From  
The Member-Secretary,  
Madras Metropolitan  
Development Authority,  
8, Gandhi-Irwin Road,  
Madras:600 008.

Letter No. B1/8452/93

Dated: 15.10.93

Sub: MMDA - APU - <sup>proposed</sup> Construction of  
Residential/~~Commercial~~ Building  
at RS.No. 180/1A, 1C Door No. 31, Kodungaiyur village,  
Remittance of D.C., S.F., S.D., <sup>Madras.</sup>  
O.S.R., S.D. for upflow filter - <sup>Ragubwater charge,</sup>  
Requested - Regarding.

Revised plan

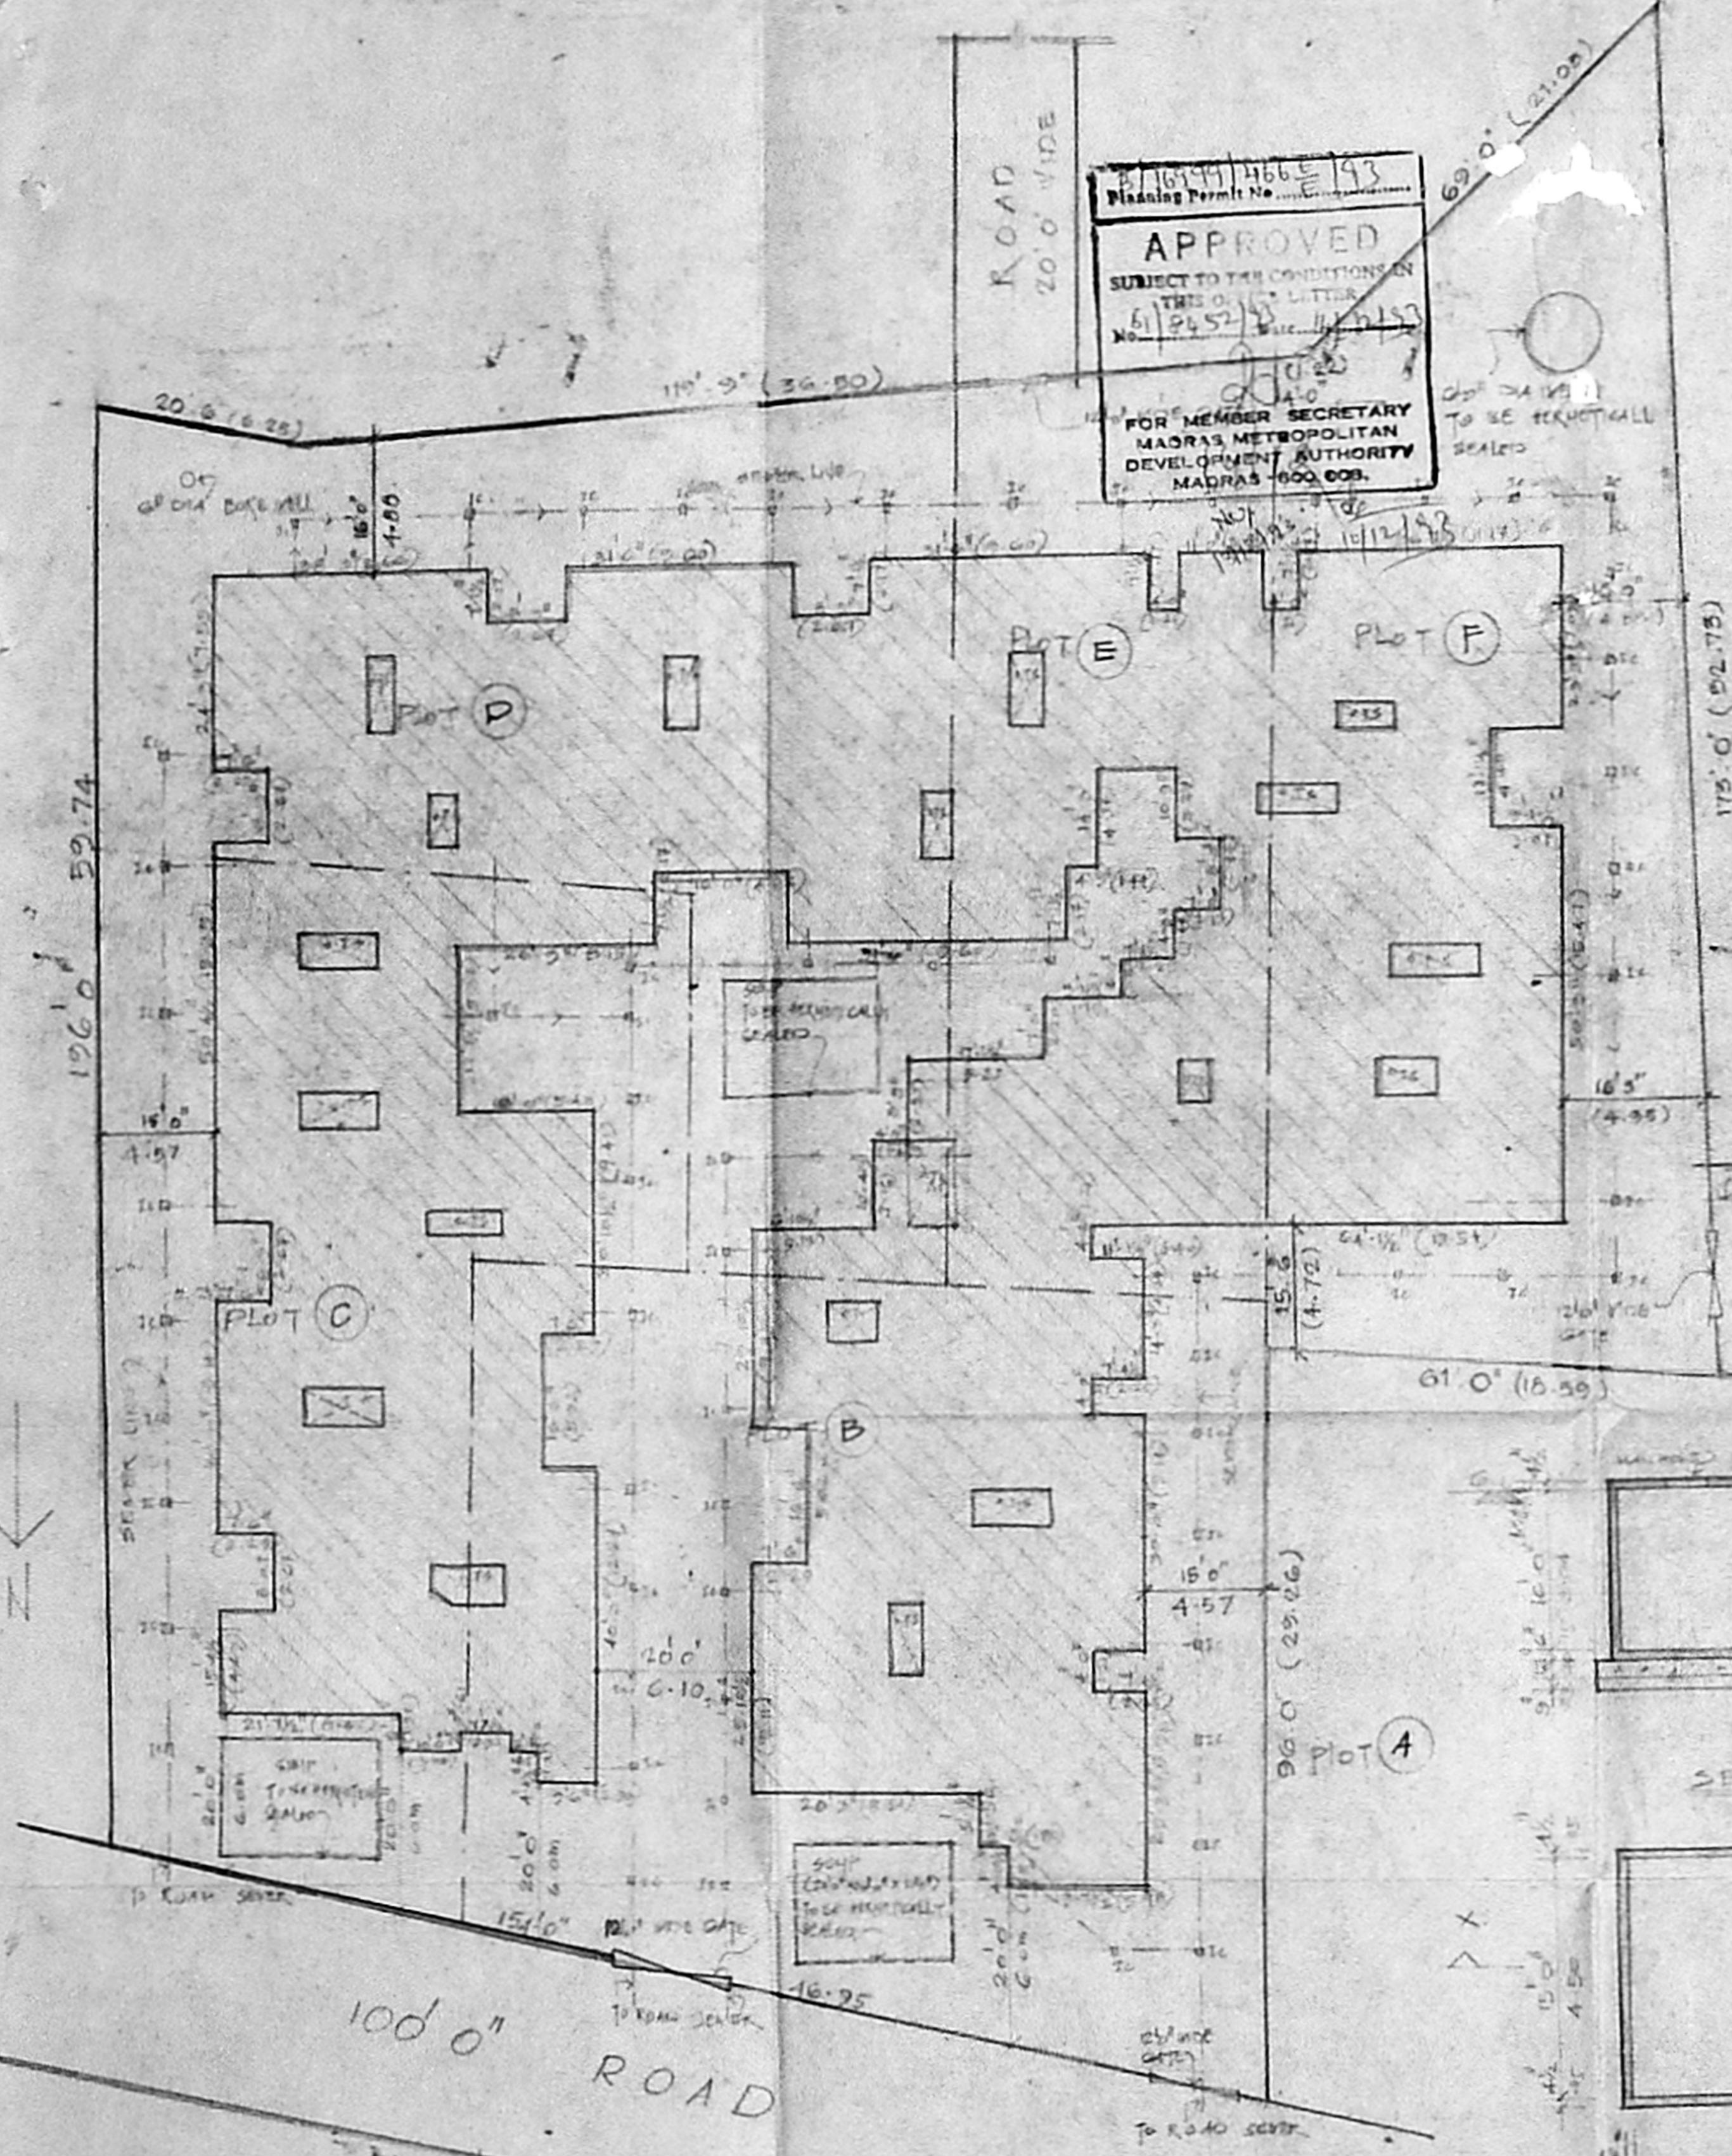
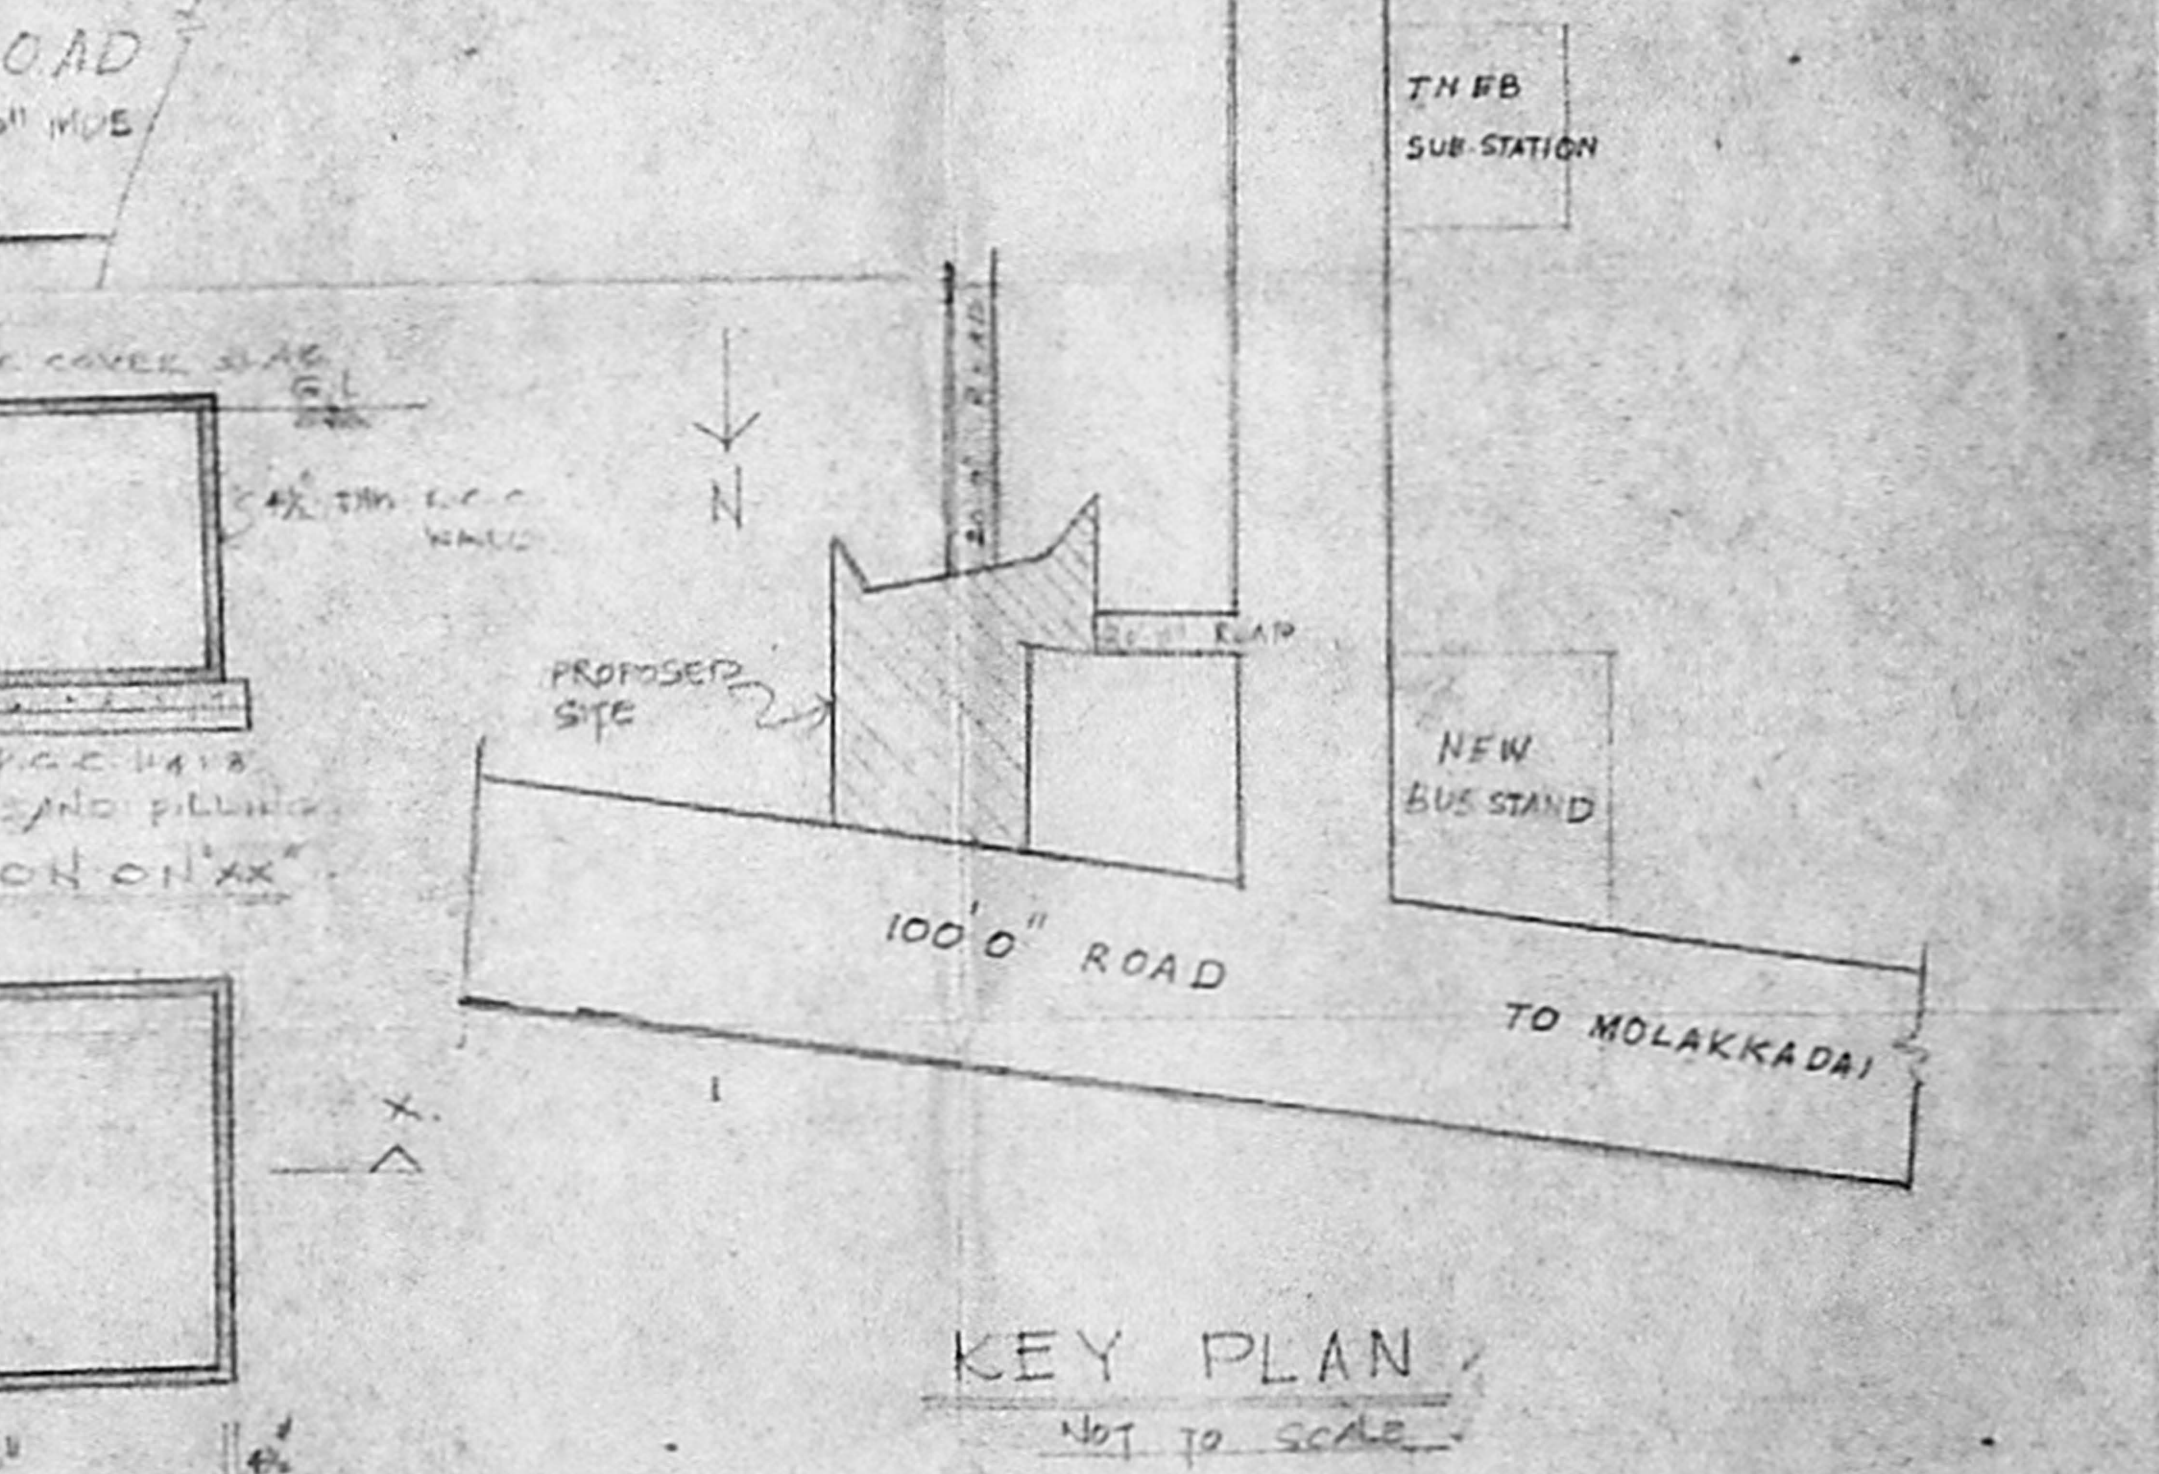
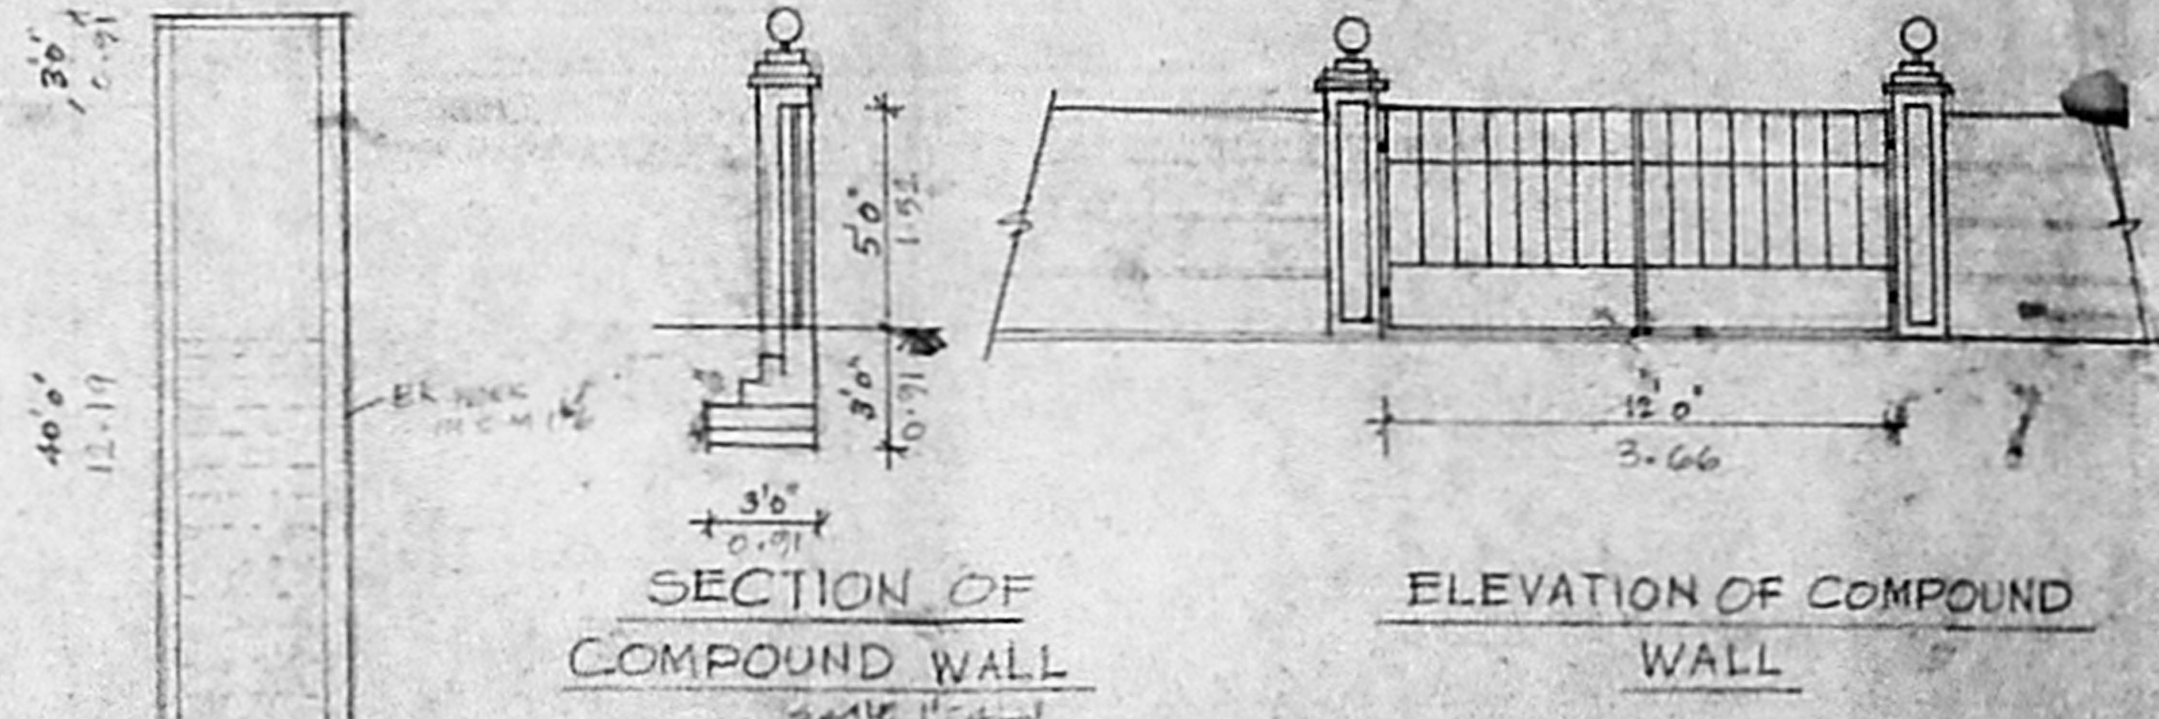
g) \* you are requested to furnish revised ~~plans~~ site plans (S.NOs) tallying the site boundary measurements with F.M.B sketch. ...4..
